From: Contact Centre (CRM) <contact@ribblevalley.gov.uk>
Sent: 21 February 2024 18:56
To: Planning
Subject: Planning Application Comments - 3/2023/1011 FS-Case-588918175

Planning Application Reference No.: 3/2023/1011

Address of Development: Capital takeaway, Wellgate

Title: Proposed Elevations	Drawn: AA							
Client: Wajid Mahmood	Checked:							
Date: 05-03-2024	Paper: A3							
Drawing No: HAD 3858-07	Scale: 1:100							
Revision:	<table><tr><td>a</td><td>b</td><td></td><td></td><td></td><td></td><td></td></tr></table>	a	b					
a	b

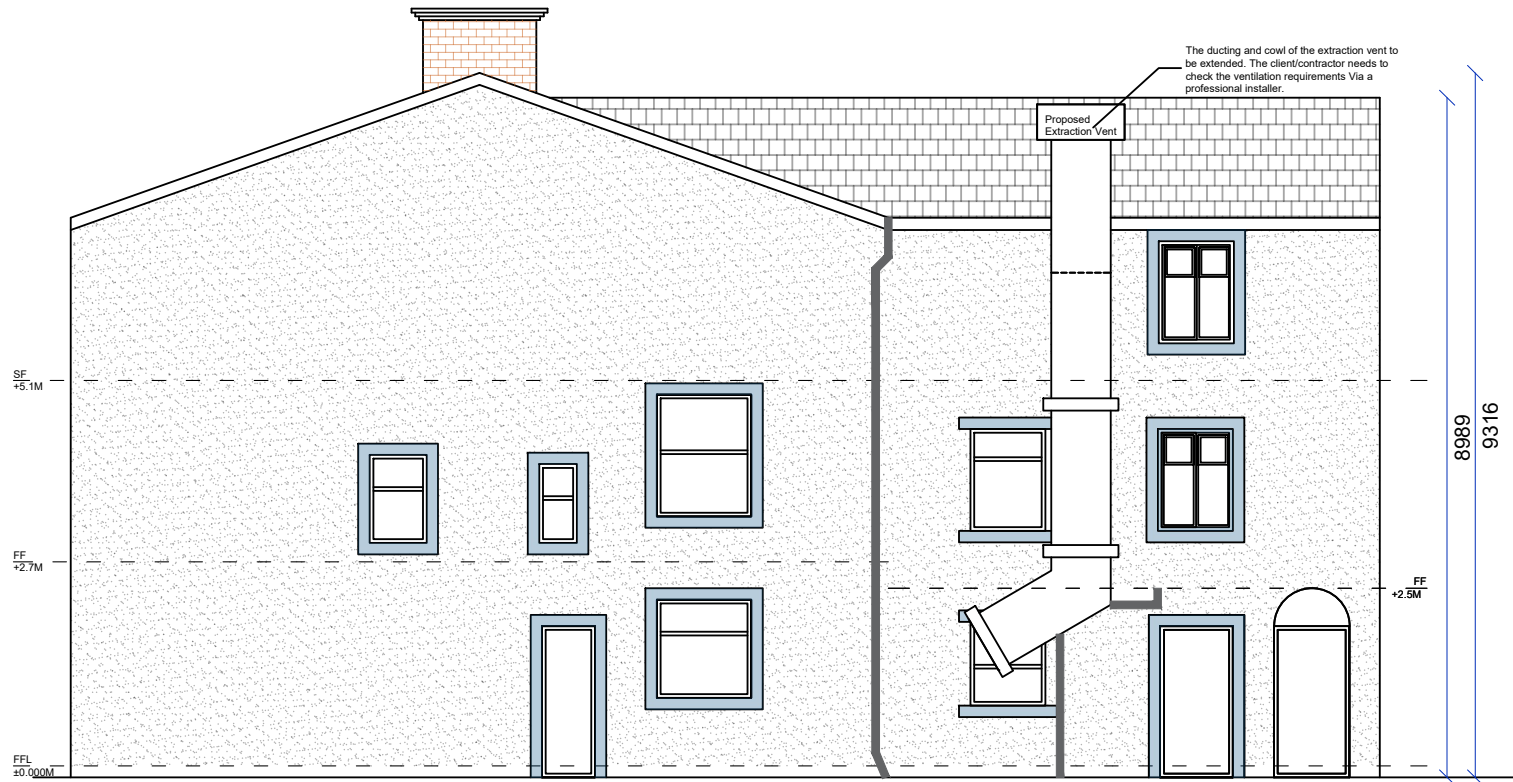
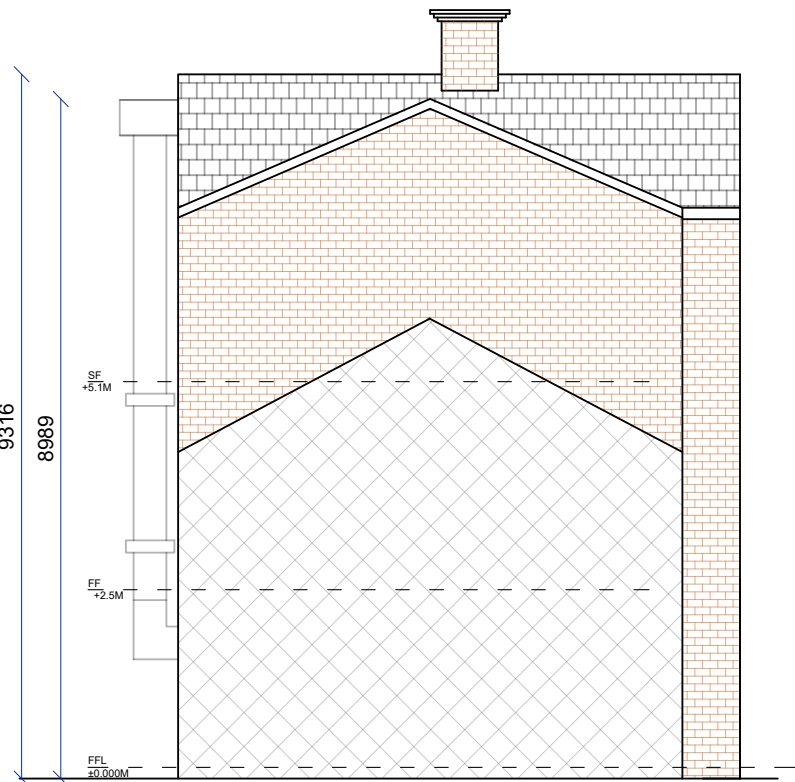
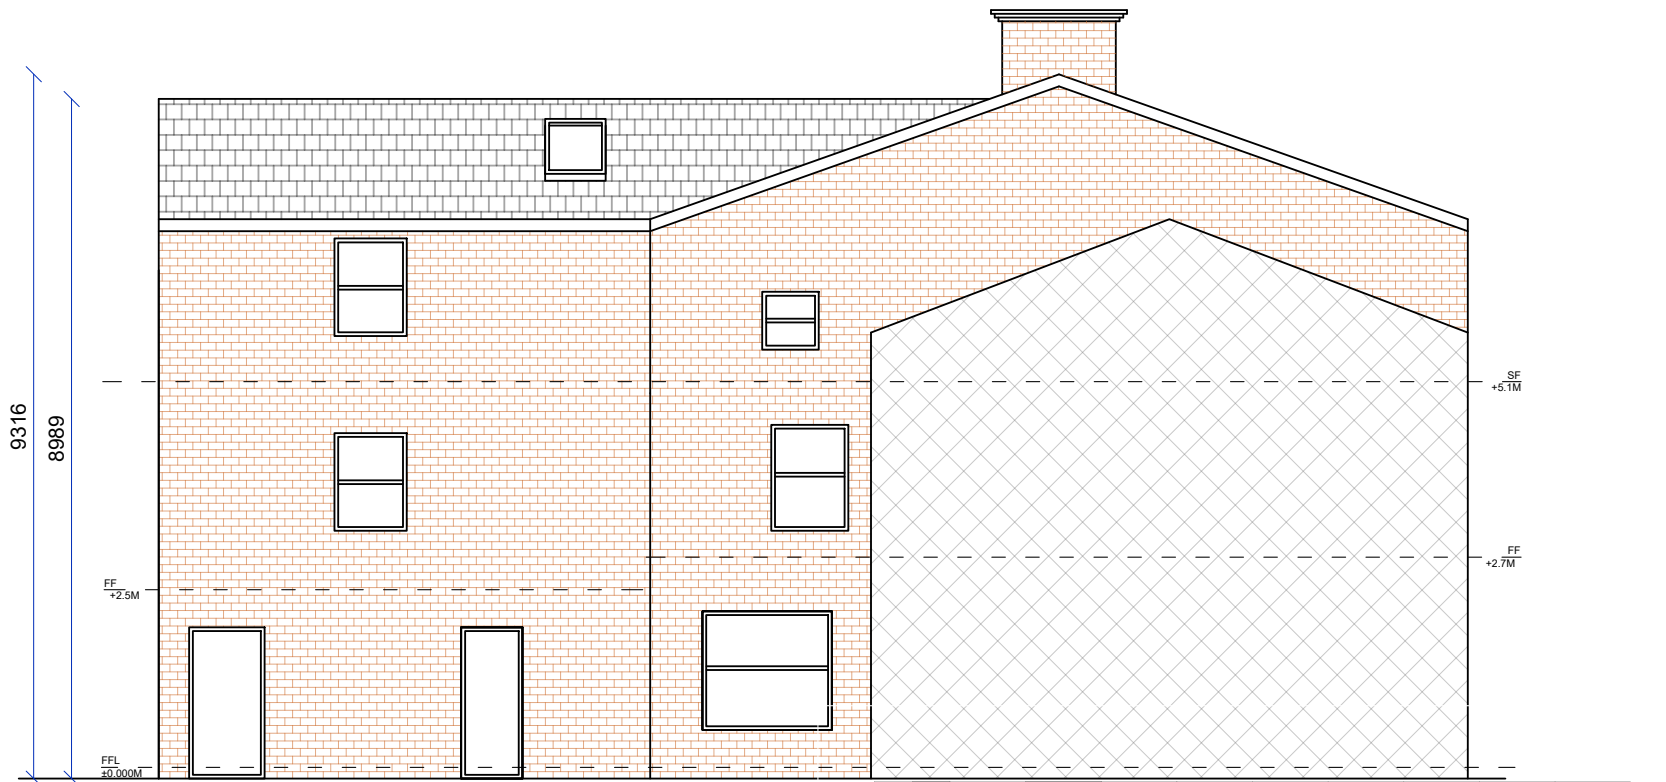
Comments: I submit comments on behalf of [REDACTED] in principle we have no objection to re-purposing the property's upper storeys to residential use. Concerns that we do hold though are around the impact on the Conservation Area, particularly at this location where there is the listed Dog and Partridge pub and also Heild Well in very close proximity. The scale of the intended extension work may result in the property being overbearing and losing it's relationship with the existing street scene and setting. Very careful consideration must be given to the height of the extension which will be visible from the conservation area.
